**SOPA SITE 3  
AUSTRALIA TOWERS**

**S75W ACCESS REVIEW**

**Morris-Goding Accessibility Consulting**

16 May 2012

Revision E - Section 75W Amendments.
1 Four spaces have been converted to two disabled spaces to accommodate increase in total adaptable apartments numbers (additional 2, from 59 to 61)

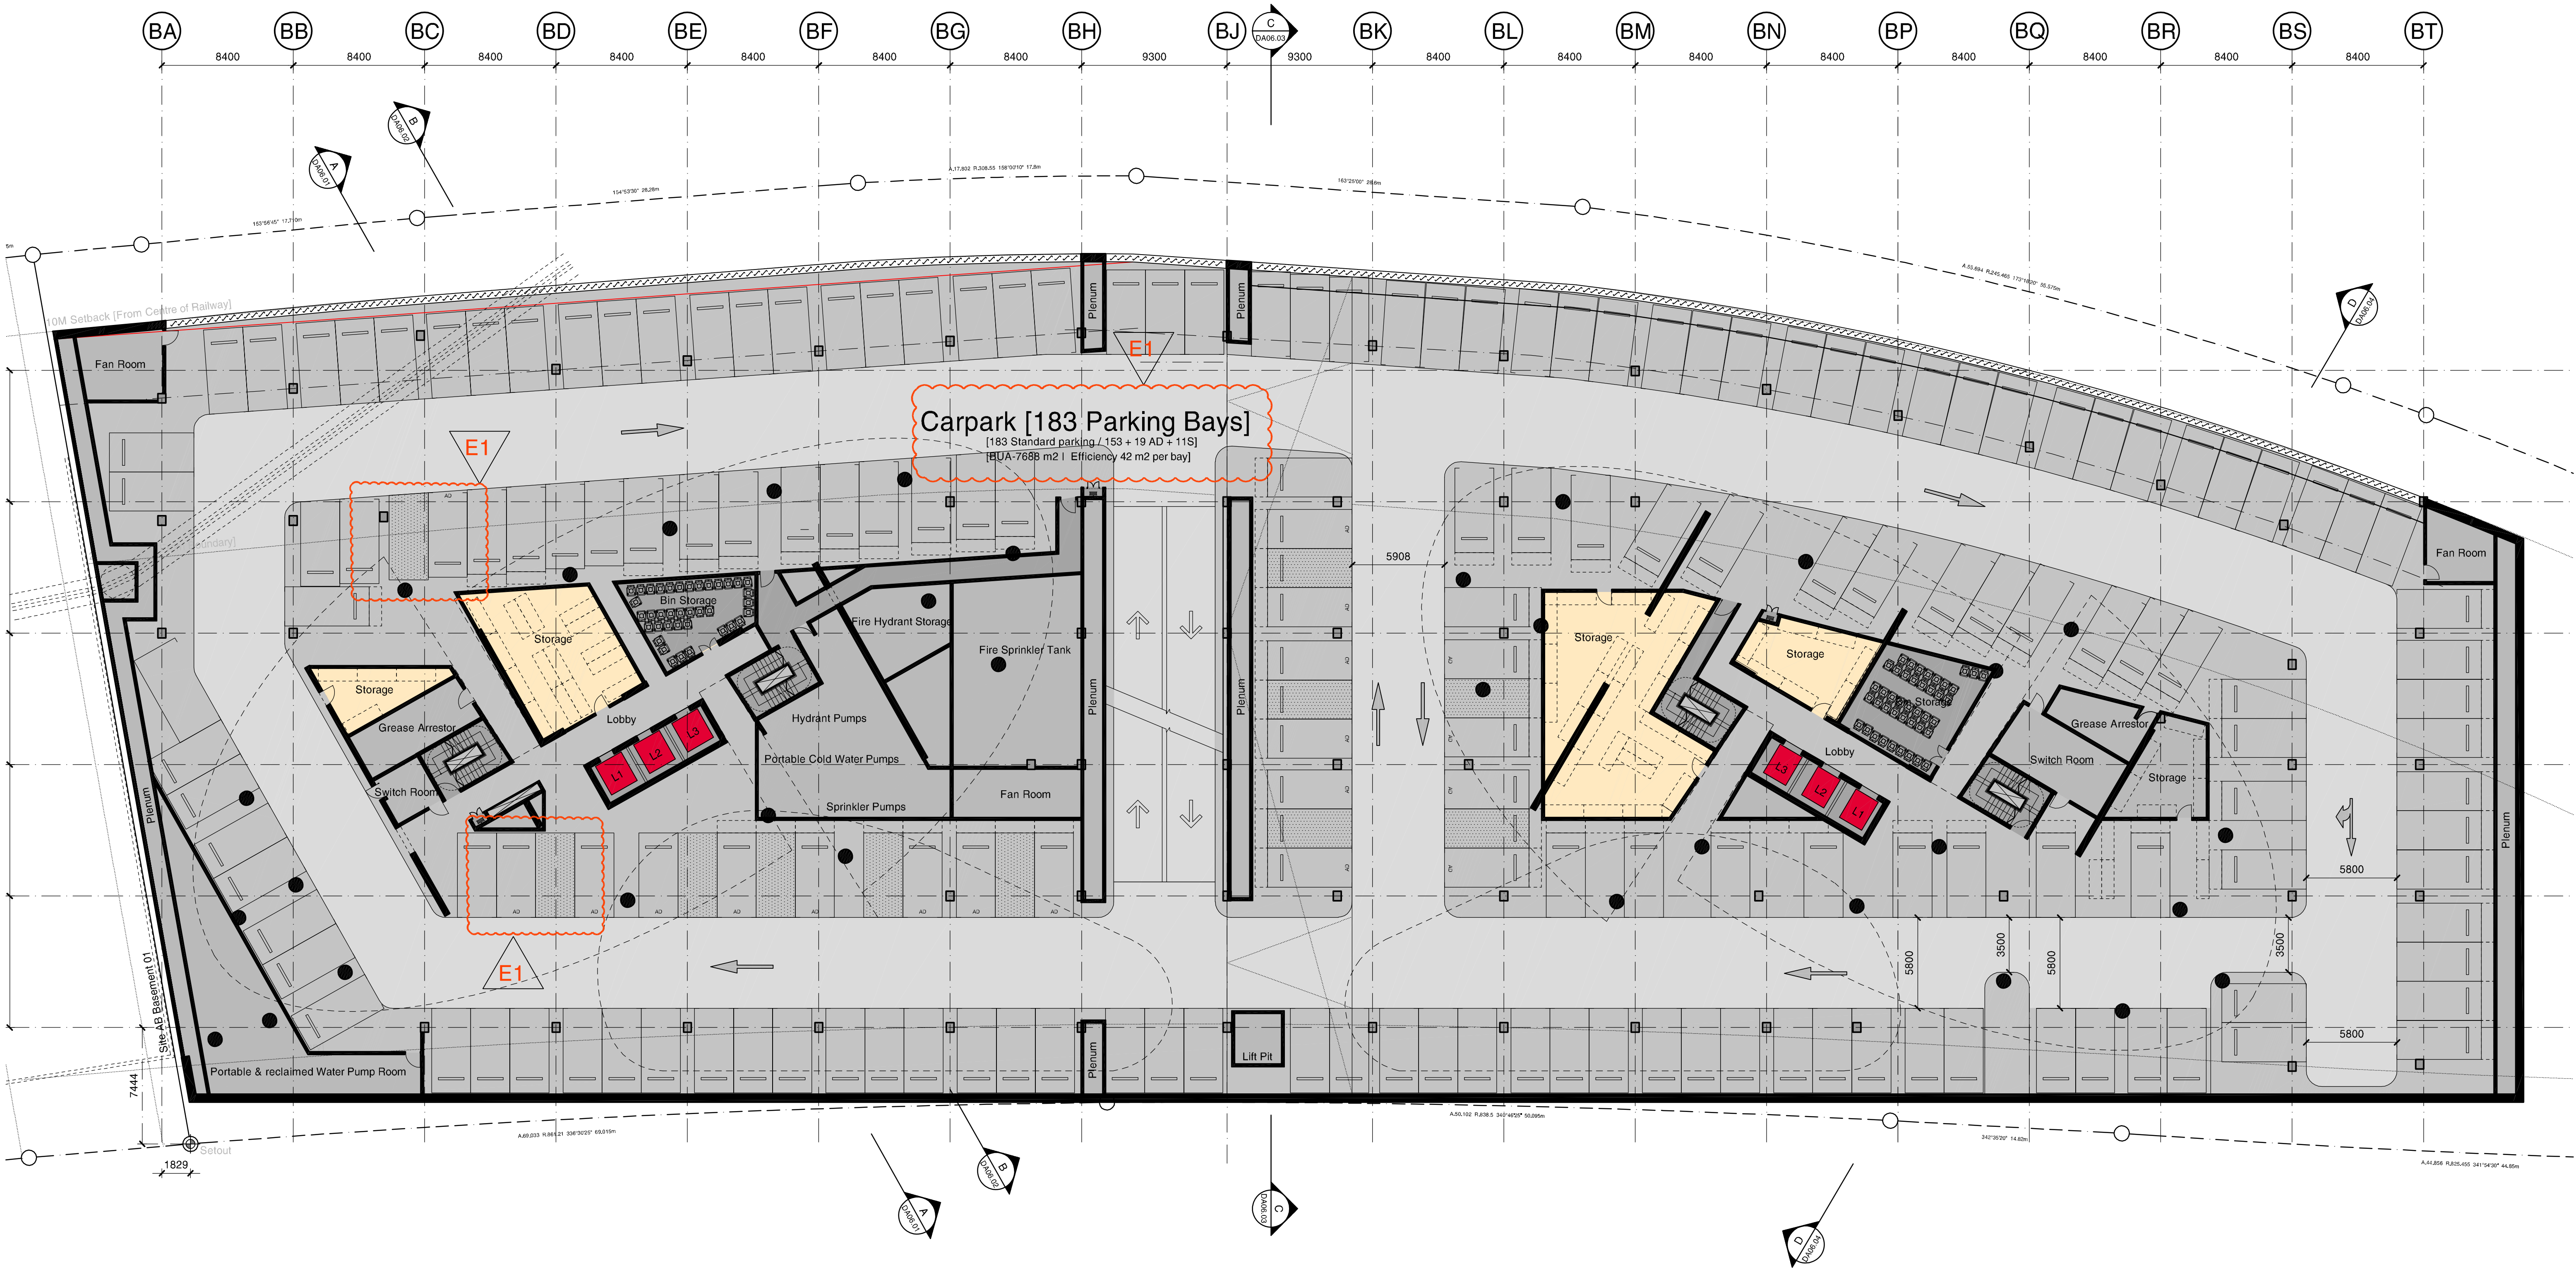
From the ground floor car parks, entry to the lobby areas is via corridors with 1600mm clear widths suitable for a person in a wheelchair to perform 180° turns in accordance with AS1428.1:2009. The doors have suitable minimum 880mm clear widths suitable in accordance with AS1428.1:2009. From the accessible car bays, a clear accessible path of travel to the lift lobby is required. Access currently is impeded by car parking columns and car bays. A suitable accessible path of travel is required.

- (i) Provide appropriate circulation area and access around the door that interfaces between corridor access (to lift lobbies) and the ground floor carpark area. It is advised that a shared zone be located in front of this door.

Site 3
Sydney Olympic Park
Plan
Basement 001

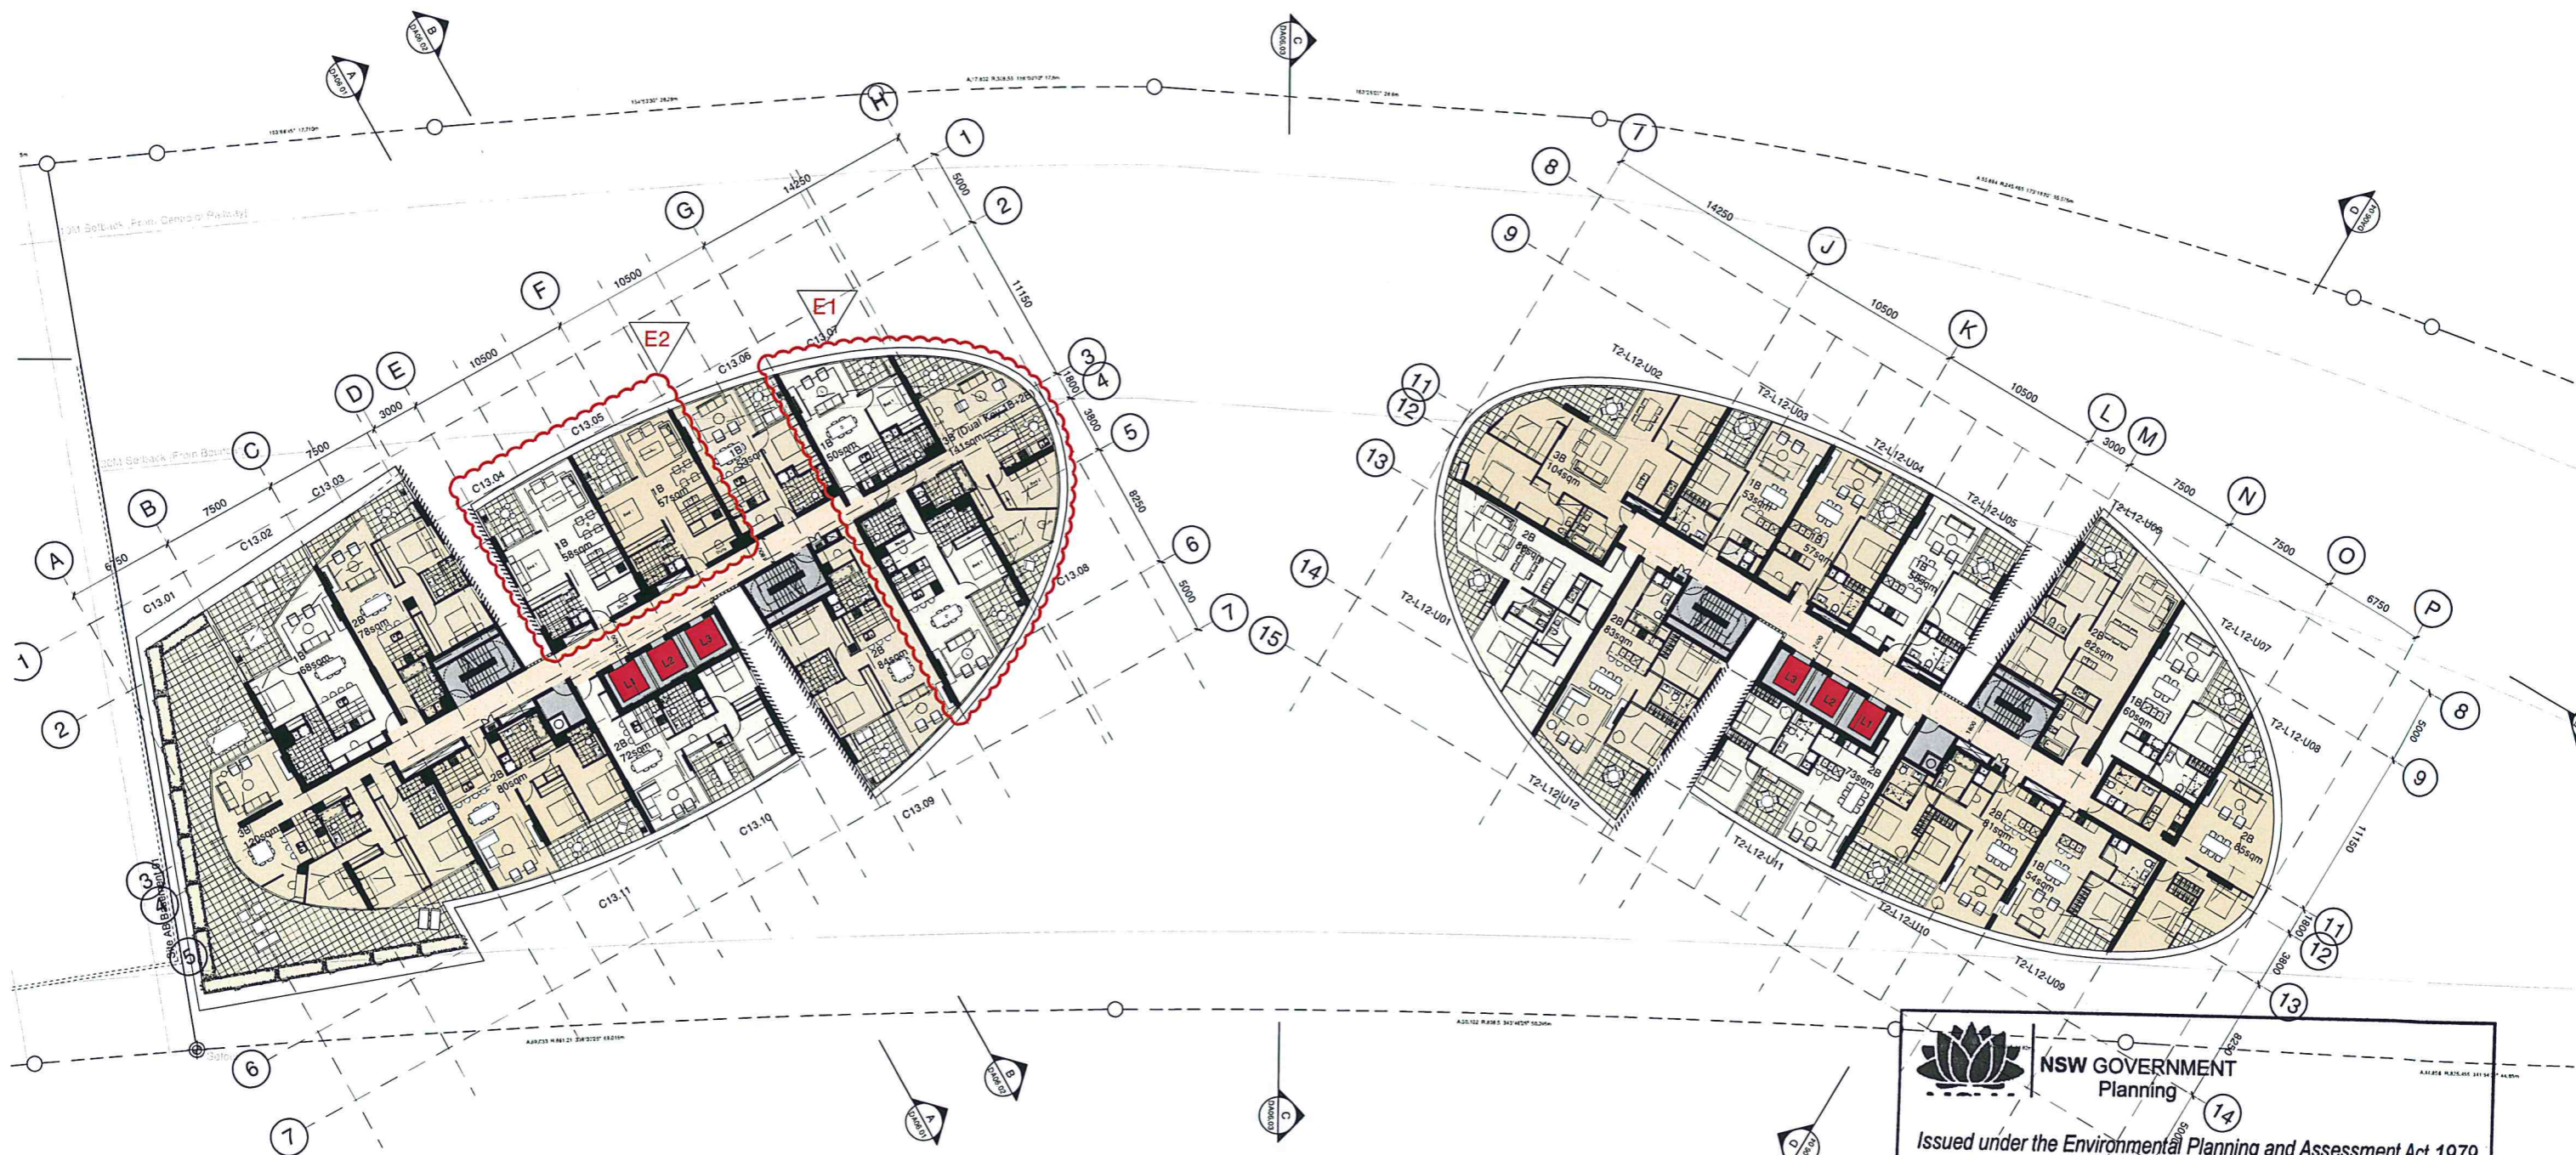
- (i) All adaptable car bays require a height clearance of 2.5 metres compliant with AS2890.1 and SOPA Access Guidelines.
- (ii) The approach to each adaptable car parking bay should have vertical clearance of not less than 2.2m in accordance with AS2890.1 and SOPA Access Guidelines.
